Case Ref: EN010119

Date: 22 August 2024

Planning Act 2008 (as amended) – Section 51

Application by North Falls Offshore Wind Farm Ltd for an Order Granting Development Consent for the North Falls Offshore Wind Farm Advice following issue of decision to accept the application for examination.

**NORTH FALLS**  
Offshore Wind Farm

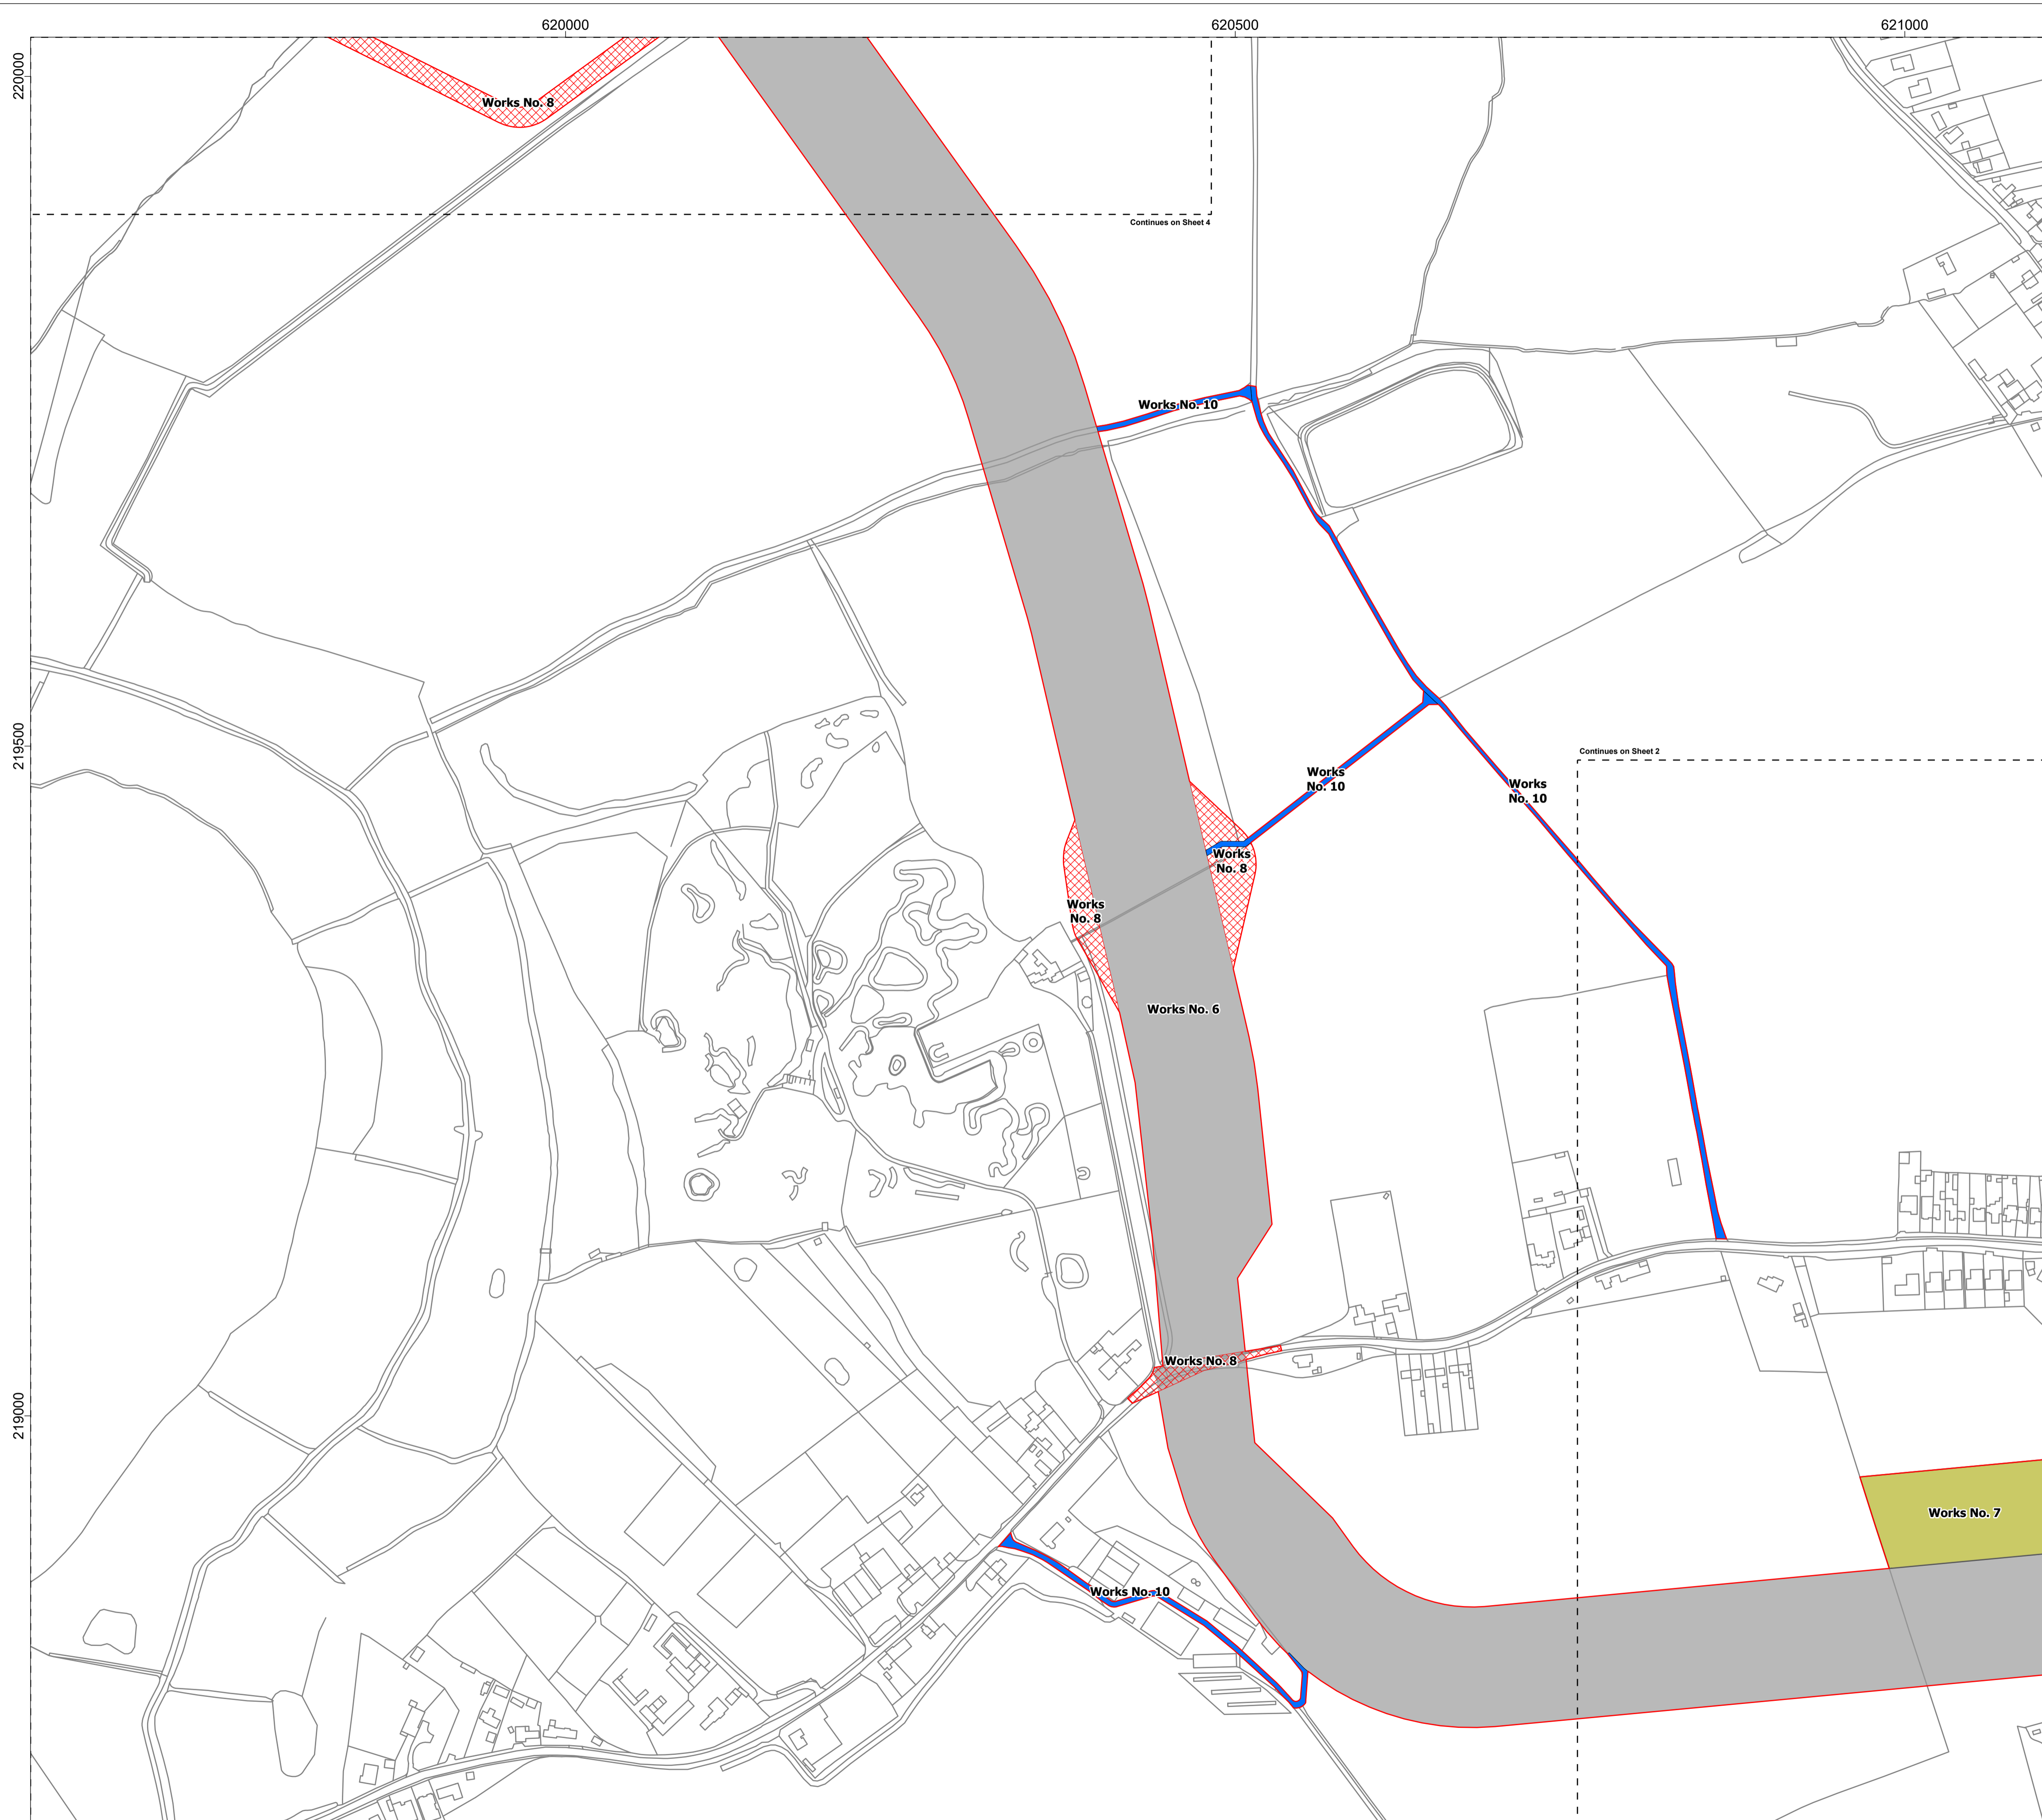
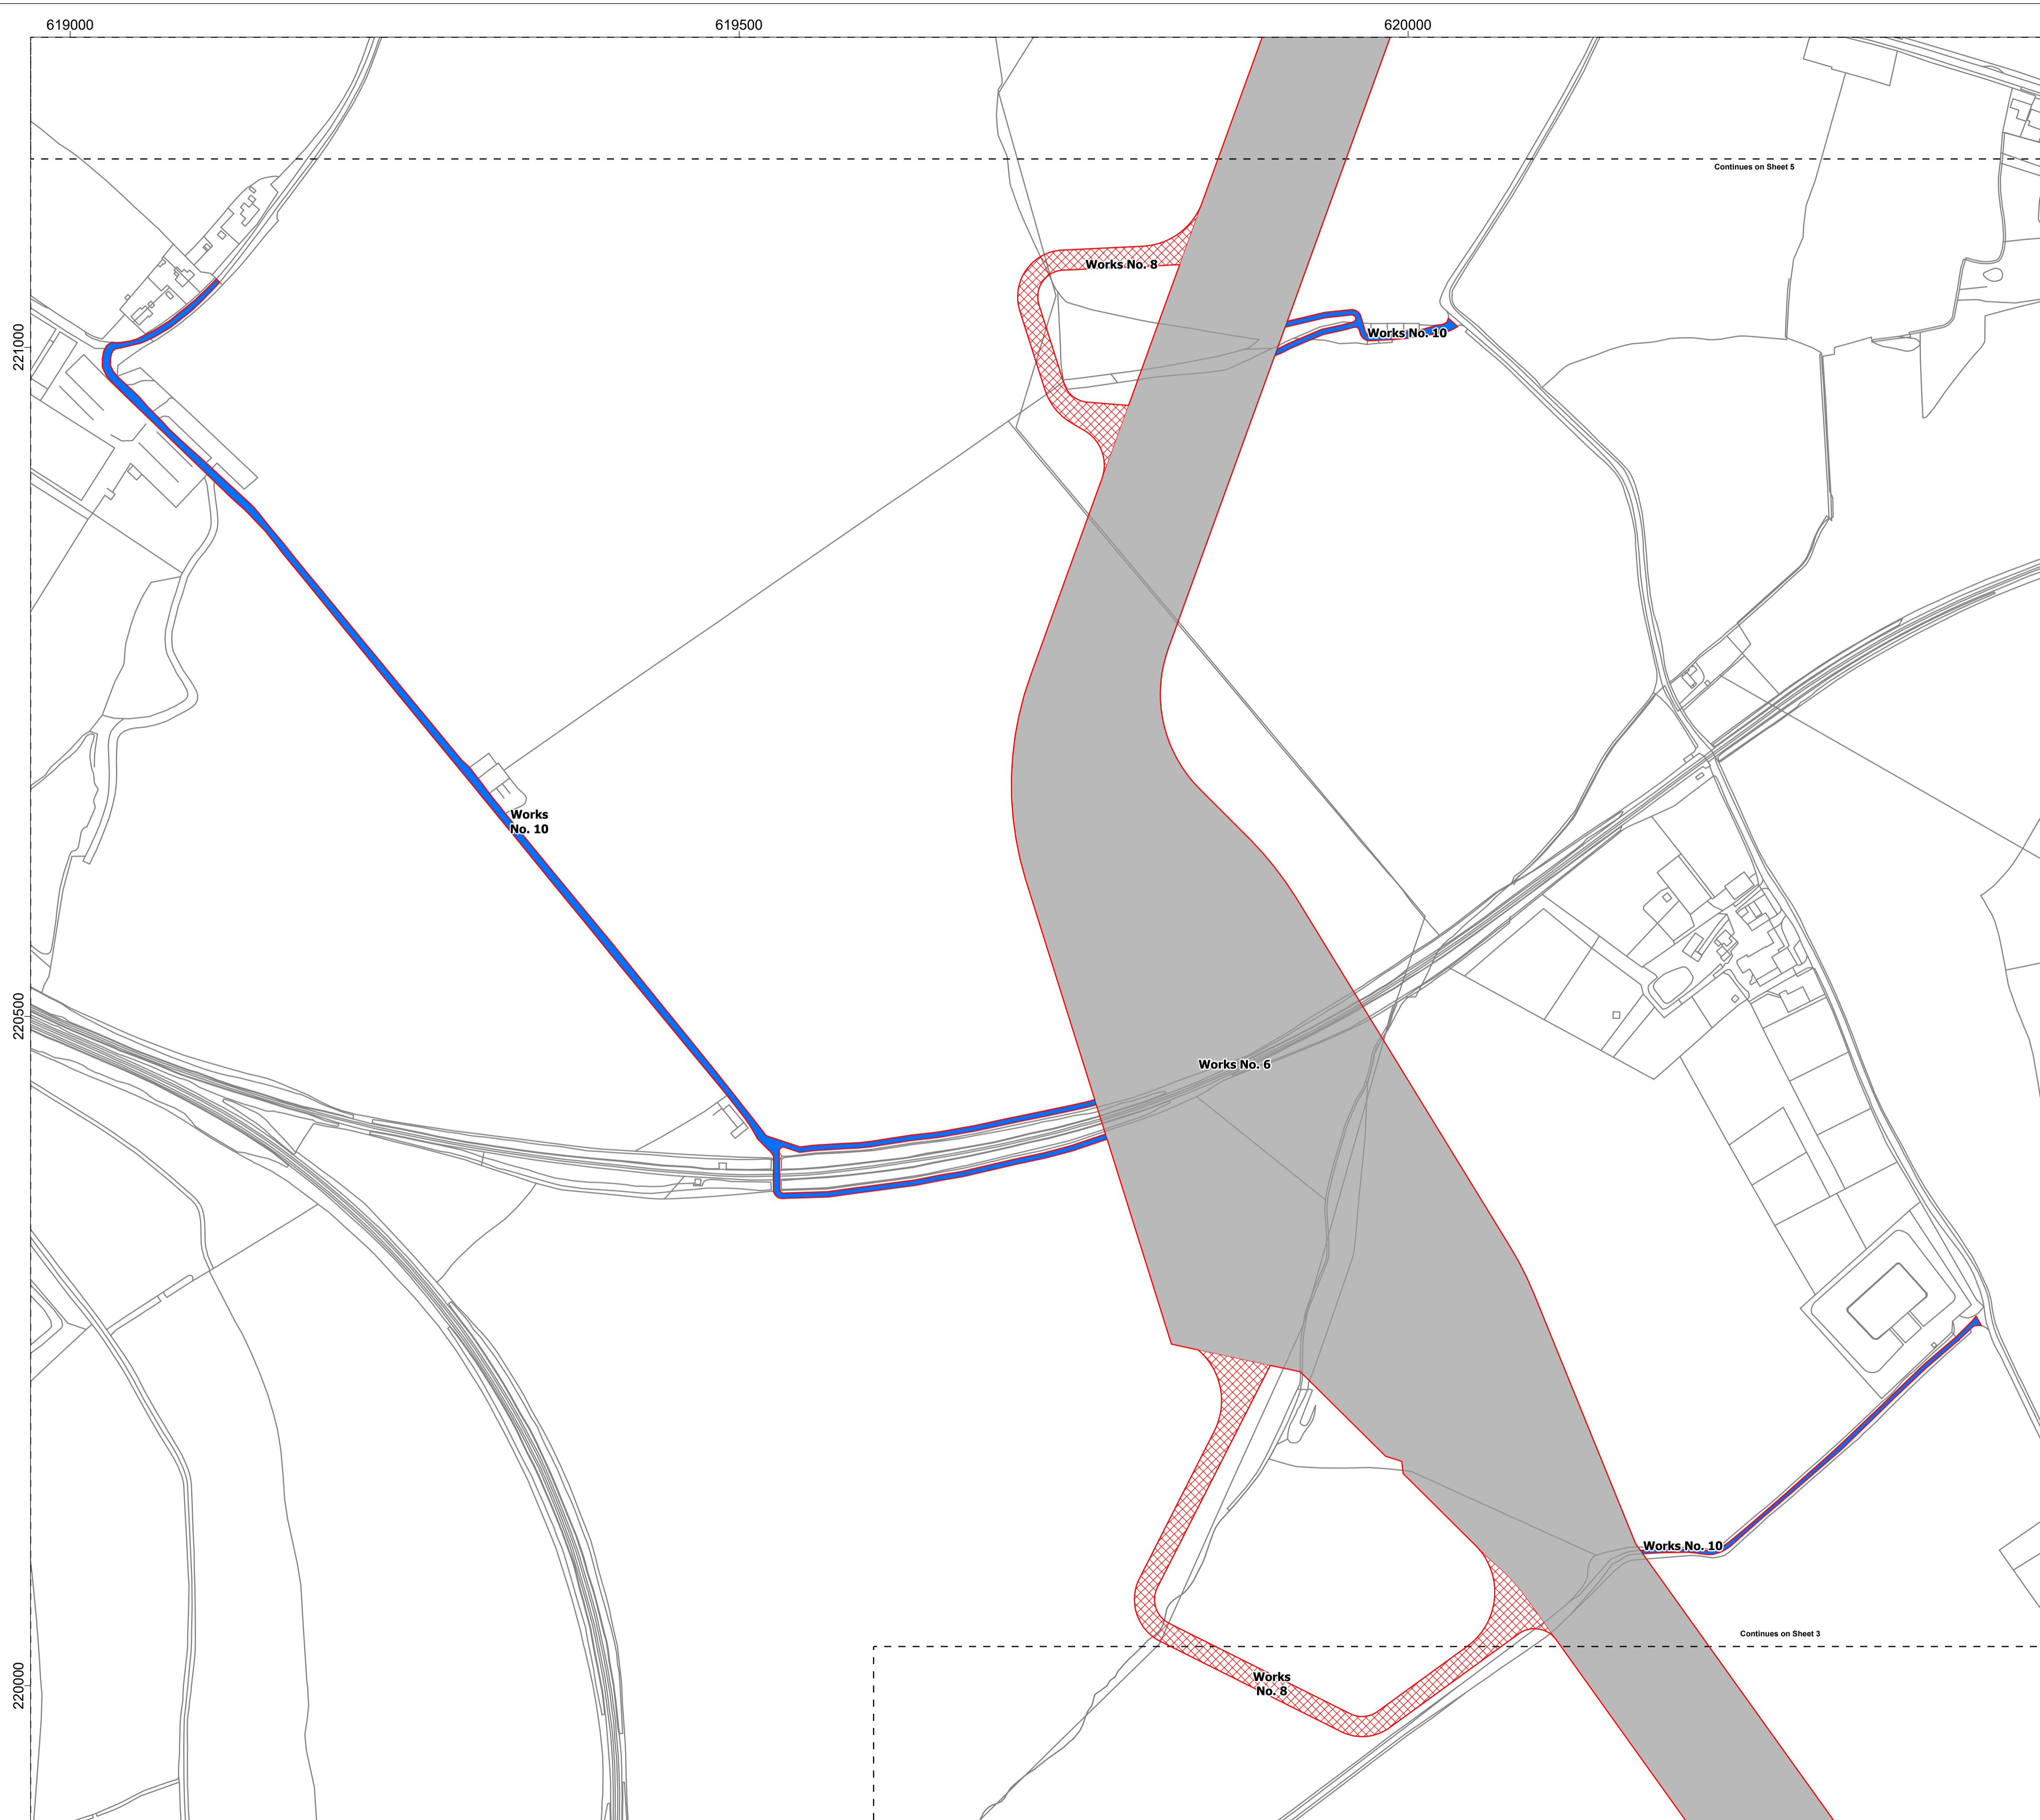
Summary descriptors are not provided for each work area. The Works Plans do not contain any identifying information, such as village or road names, which are shown on the Location Plans. Adding summary descriptors, local place and road names to the Works Plans would aid understanding for stakeholders. Similarly, the location of the 'red line' boundary must be clear in all areas. Once identifying information labels are added to the plans, please ensure that these can be digitally searched. This should be provided to the Planning Inspectorate for publication as early as possible before the commencement of the Examination.
